Response to Submissions Report

State Significant Development – SSD 9912

Roseville College – New Sport and Wellbeing Centre Development

27-29 and 37 Bancroft Avenue, Roseville

Original SSDA perspective
View from No.39

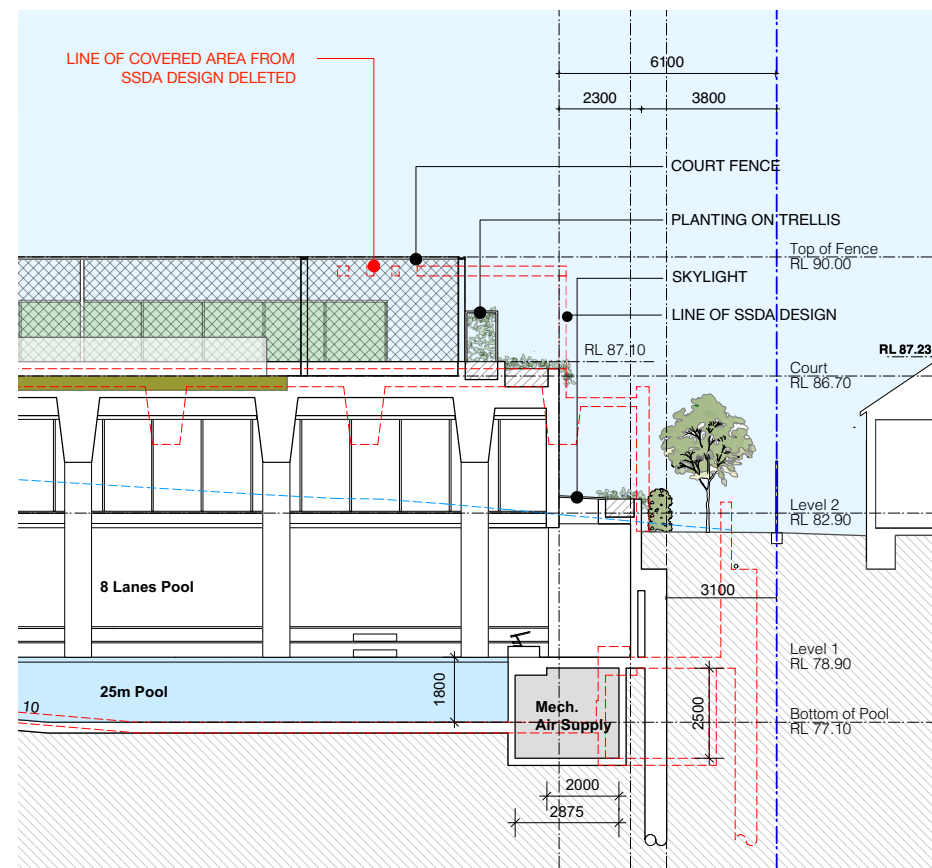
Provide additional site layout plan and detailed sections at a larger scale (including sections with and without landscaping) that clearly depict the proposed interface along the boundary between 39 Bancroft Avenue and the proposed development. These should clearly detail the proposed levels, fencing and landscaping, including soil depths.	<p>These details have been provided in the revised Architectural design package prepared by BHA, Architectural Comparisons prepared by BHA and revised Landscape designs prepared by Sym Studios. Please also refer to Section 7 below for additional information on the eastern boundary interface with 39 Bancroft Avenue</p>	<p>Appendix 2 (Architectural Plans)</p> <p>Appendix 4 (Architectural Comparisons)</p> <p>Appendix 6 (Landscape plans)</p>
<p>Trees and Landscaping</p> <p>Address the concerns raised by Council in relation to the removal of Tree No. 7, the proposed landscape design and lack of deep soil planting along the eastern boundary.</p>	<p>As a result of on-going consultation with Council, Tree 7 is now retained. Please refer to the revised Landscape design package and Arboricultural Impact Appraisal and Method Statement accompanying this report.</p>	<p>Appendix 6 (Landscape plans)</p> <p>Appendix 7 (Arborist Statement)</p>

<p>Key issues raised by 39 Bancroft Avenue:</p> <ul style="list-style-type: none">• Demolition of a house in the Clanville Heritage Conservation Area• Bulk and scale of the development• Imprisonment effect• Loss of privacy and amenity• Noise and acoustic impact• Loss of solar access and overshadowing• Excavation vibration• Hours of Operation• Insufficient building setbacks• Hours of Work	<div><div><p>Section A through pool hall</p></div><div><p>Section B through classrooms</p></div></div> <p>Figure 5 Comparison sections showing original proposal (in red) compared to revised design in the interface zone</p> <p>Figure 6 and Figure 7 below shows the changes which have been made as viewed from the rear yard of 39 Bancroft Avenue.</p>	<p>Section 2</p> <p>Section 7</p> <p>Appendix 2 (Architectural Plans)</p> <p>Appendix 3 (Architectural analysis information)</p> <p>Appendix 4 (Architectural Comparisons)</p> <p>Appendix 10 (SoHI)</p>

Issue	Response	Reference
	<p>As discussed in Section 2 of this report, the project team has consulted with the owners of 39 Bancroft Avenue in the design development of the revised architectural package. Minutes (file note) of a meeting with the owners held via video conference on 28 May 2020 accompanies this report (the minutes/file note were confirmed via email from the owners of 39 Bancroft Avenue on 15.07.2020 as reflecting the discussions in the meeting of 28.05.2020).</p> <p>As can be seen in the file note, additional information was requested by the owners of 39 Bancroft Avenue, this was provided via email from Roseville College on 06.07.2020 in the form of 3D perspective drawings, suggested plantings and notations.</p> <p>A response was received from the owners of 39 Bancroft Avenue via email on 15.07.2017 which in summary:</p> <ul style="list-style-type: none">• Suggested plantings proposed were an improvement and were generally acceptable;• Made suggestions for the inclusion of lower growing vegetation for certain areas of the site and moving certain species to certain areas on site;• Gave preference for use of certain species over others; and• Sought confirmation of levels of the proposed development. <p>The information sought in the final dot point above was provided to the owners of 39 Bancroft Avenue 18/08/2020 in the way of marked up section showing original and revised levels.</p> <p>The revised design is considered to be responsive to the concerns raised by the DPIE, Council and the owners of 39 Bancroft Avenue. Appendix 4 contains 'Architectural Comparison' plans prepared by BHA.</p> <p>Figure 5 below provides details of the interface zone between 37 and 39 Bancroft, comparing the original proposal (in red) to the revised design. These section highlight the increased building separation and ground and first floor levels, increased deep soil planting and increased landscaping on the building elevation.</p>

Issue	Response	Reference
	<div data-bbox="629 205 1647 705" data-label="Image"> </div> <div data-bbox="629 709 1359 739" data-label="Caption"> <p>Figure 6 Original SSDA proposal – view from rear yard of 39 Bancroft Avenue</p> </div> <div data-bbox="1670 205 2564 705" data-label="Image"> </div> <div data-bbox="1670 709 2163 739" data-label="Caption"> <p>Figure 7 Revised design of proposed development</p> </div> <div data-bbox="617 772 1418 823" data-label="Text"> <p><u>Demolition of a house in the Clanville Heritage Conservation Area</u> Please refer to Section 2 and Section 7 of this report as well as the SoHI in Appendix 10.</p> </div> <div data-bbox="617 844 1418 894" data-label="Text"> <p><u>Bulk and scale of the development</u> Please refer to Section 2 and Section 7 of this report as well as the SoHI in Appendix 10.</p> </div> <div data-bbox="617 915 2585 987" data-label="Text"> <p><u>Imprisonment effect</u> The reduced bulk and scale of the development, removing the rooftop/sports court skillion roof and the increased setback from 39 Bancroft Avenue is considered to significantly improve any potential amenity impacts which were arising from the original SSDA proposal.</p> </div> <div data-bbox="617 1008 2585 1100" data-label="Text"> <p><u>Loss of privacy and amenity</u> The reduced bulk and scale of the development, removing the rooftop/sports court skillion roof and the increased setback from 39 Bancroft Avenue is considered to significantly reduce any potential amenity impacts which were arising from the original SSDA proposal. There are no windows along the eastern boundary wall proposal. The classroom level is significantly setback from the eastern boundary and is not considered to create any privacy impacts. Visual screening is also provided at the sports court level (see Figure 7).</p> </div> <div data-bbox="629 1138 1730 1738" data-label="Image"> </div> <div data-bbox="676 1743 1080 1772" data-label="Caption"> <p>Figure 8 Perspective of revised proposal</p> </div> <div data-bbox="617 1785 2065 1835" data-label="Text"> <p><u>Noise and acoustic impact</u> The development application acoustic assessment at Appendix 15 has concluded that the proposal will not create unacceptable acoustic impacts within the locality.</p> </div> <div data-bbox="617 1856 2585 1927" data-label="Text"> <p><u>Loss of solar access and overshadowing</u> Please refer to shadow diagrams in the revised architectural design package at Appendix 2. With the revised design by being set further back from the eastern boundary the shadow diagrams show that the shadow cast by the proposed development will be largely confined within the site.</p> </div>
